**Representation by Deloitte LLP on behalf of North Tees Group Limited – Interested Party
Reference H2TS- AFP101**

Application by H2 Teesside Limited for an Order Granting Development Consent for the H2 Teesside Project (EN070009)

BOREHOLES LOCATED NEAR 9134 SHEET 9
THE ORANGE LINE IS THE SABIC FENCE LINE

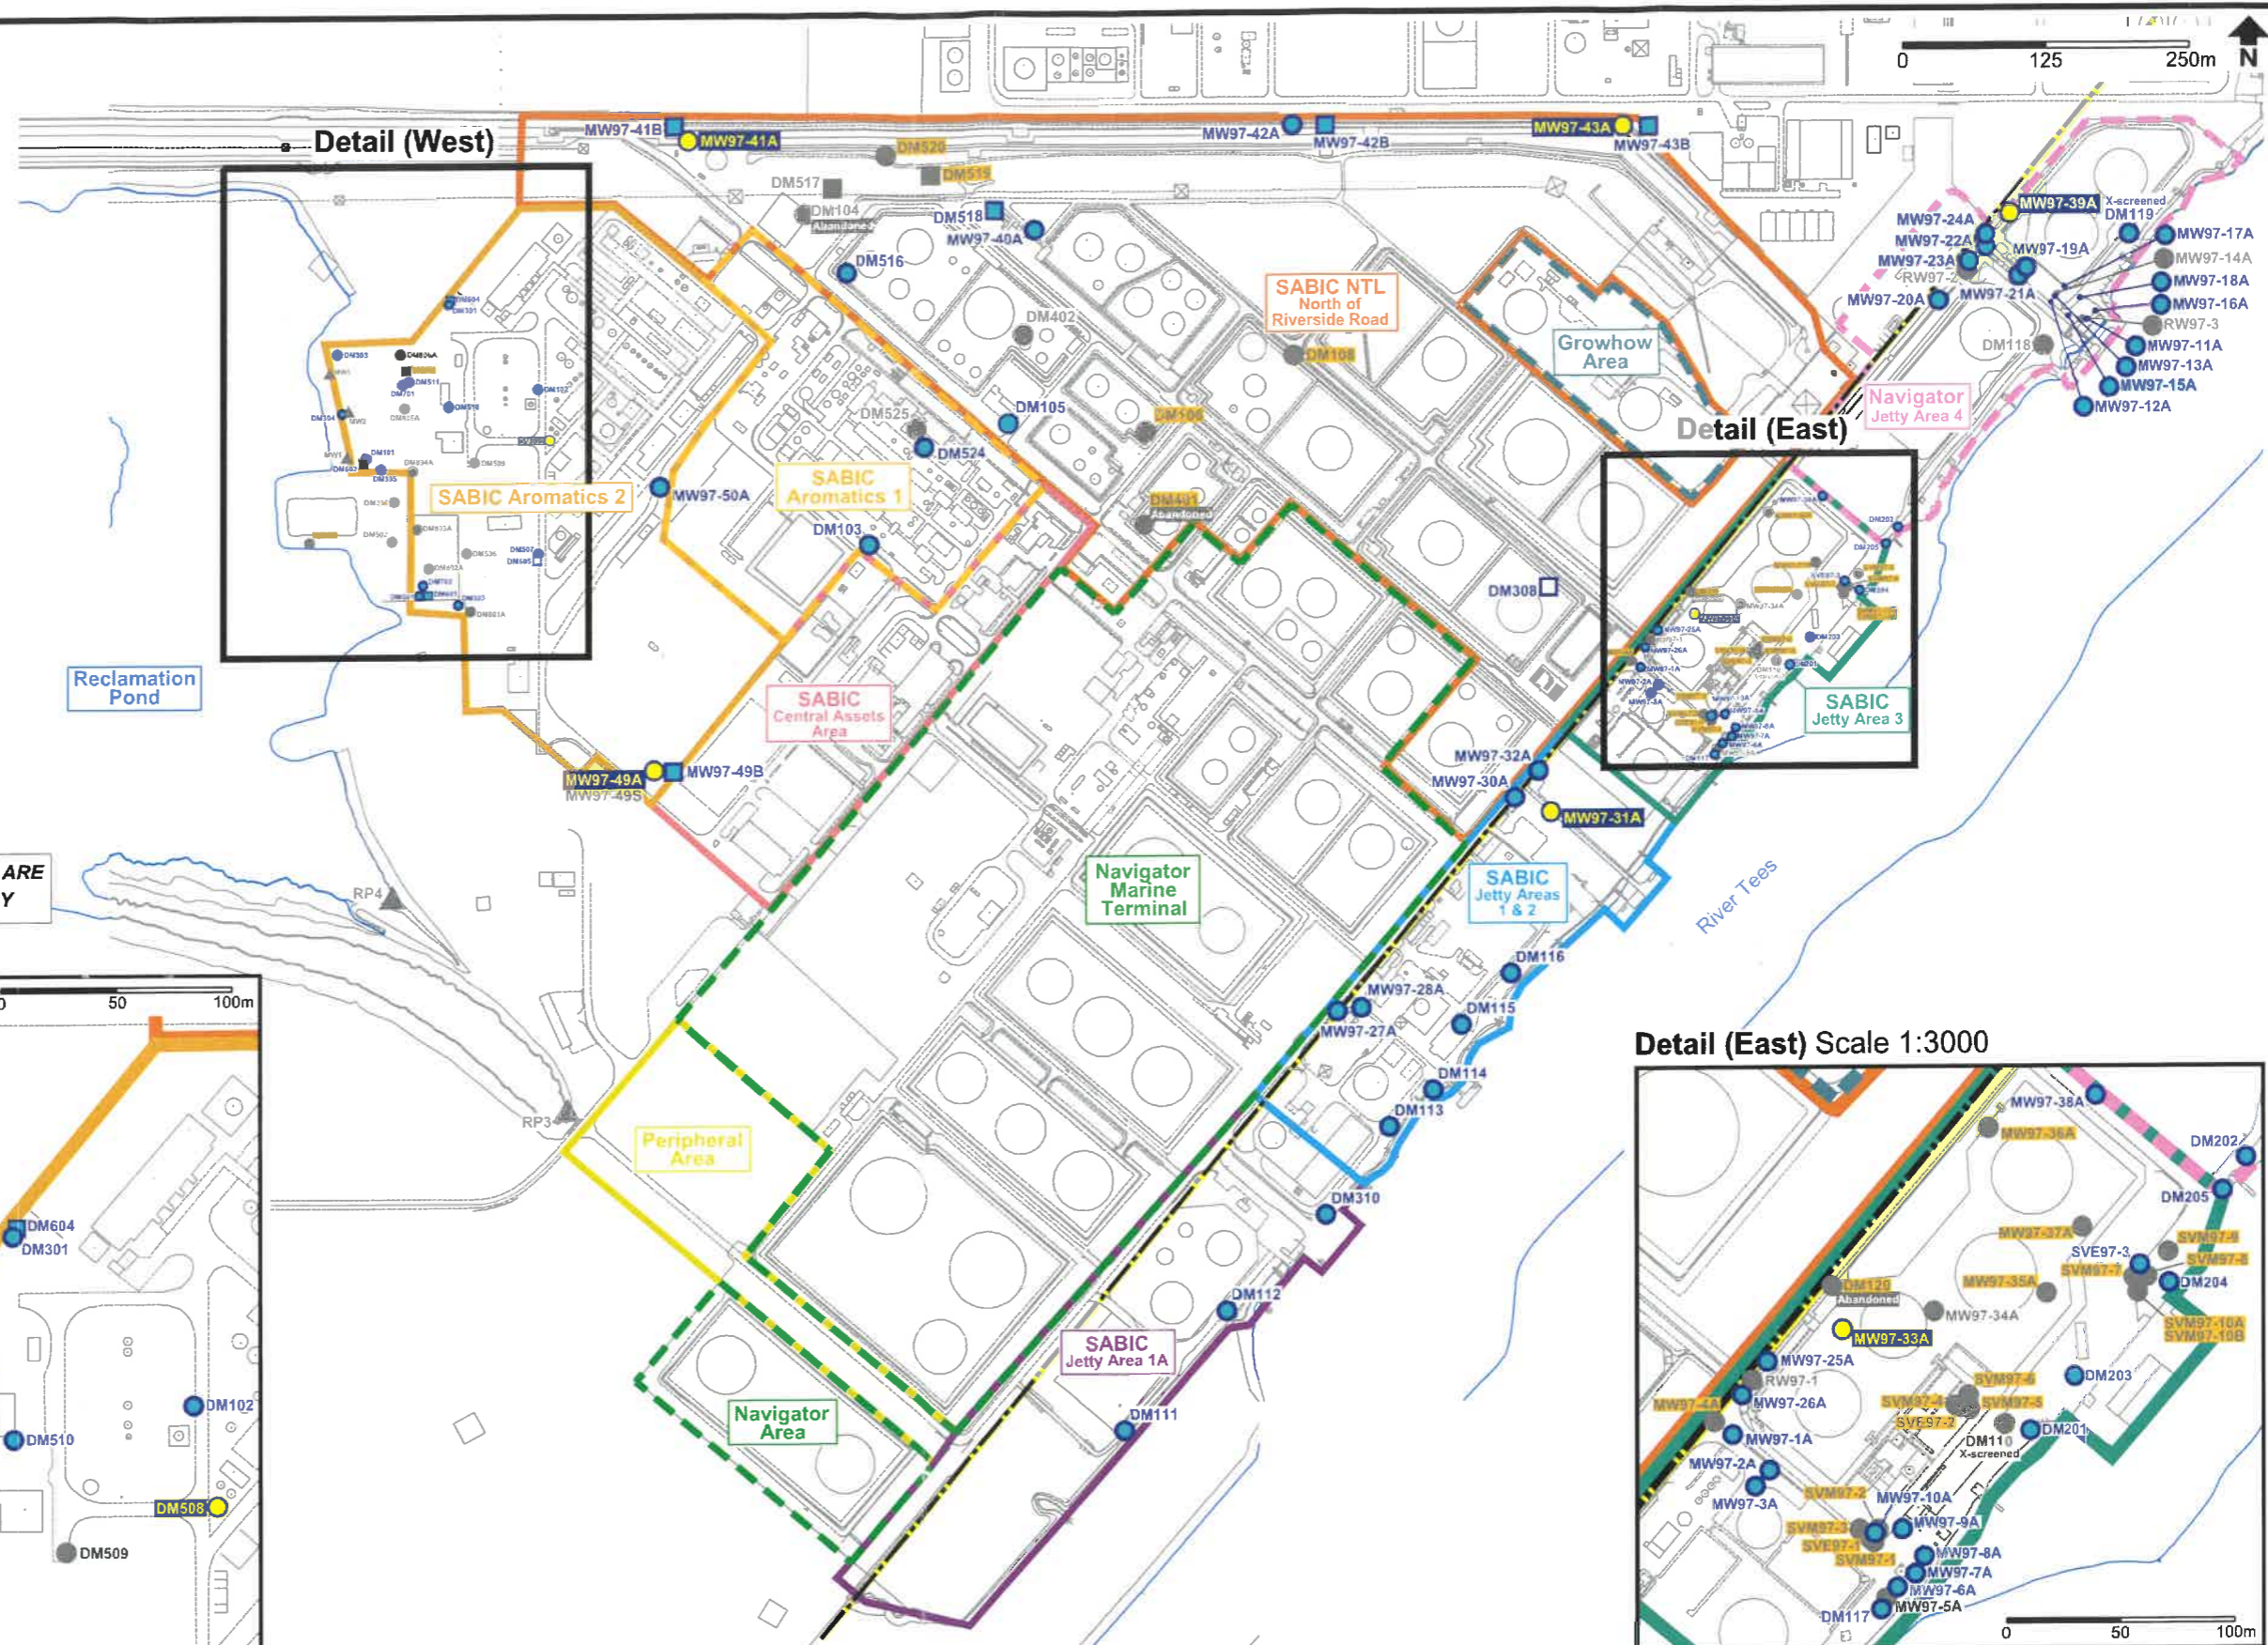
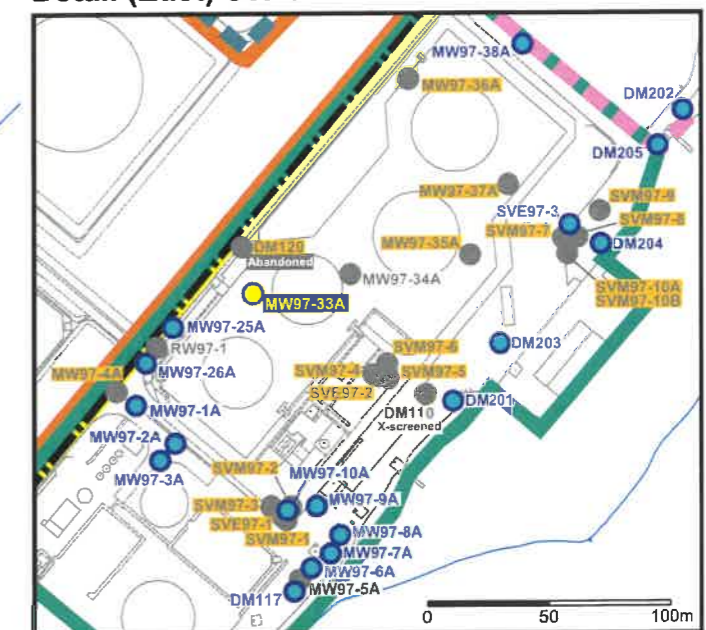
3.4.6.2 NTL maintain and manage a number of monitoring boreholes that are located within or in close proximity to land parcels 9/28, 9/27, 9/32, 9/31, 9/34 (Please see Appendix 2). These boreholes are critical infrastructure in relation to the monitoring and management of groundwater and potential contamination or migration of contamination and must therefore be protected throughout any construction period. NTL require anyone undertaking works on their land to comply with detailed rules, regulations and environmental monitoring to ensure the protection of the environment; boreholes must be maintained and not damaged in anyway. This is particularly important given the historic uses of NTL's land for the production of chemicals including petrochemicals.
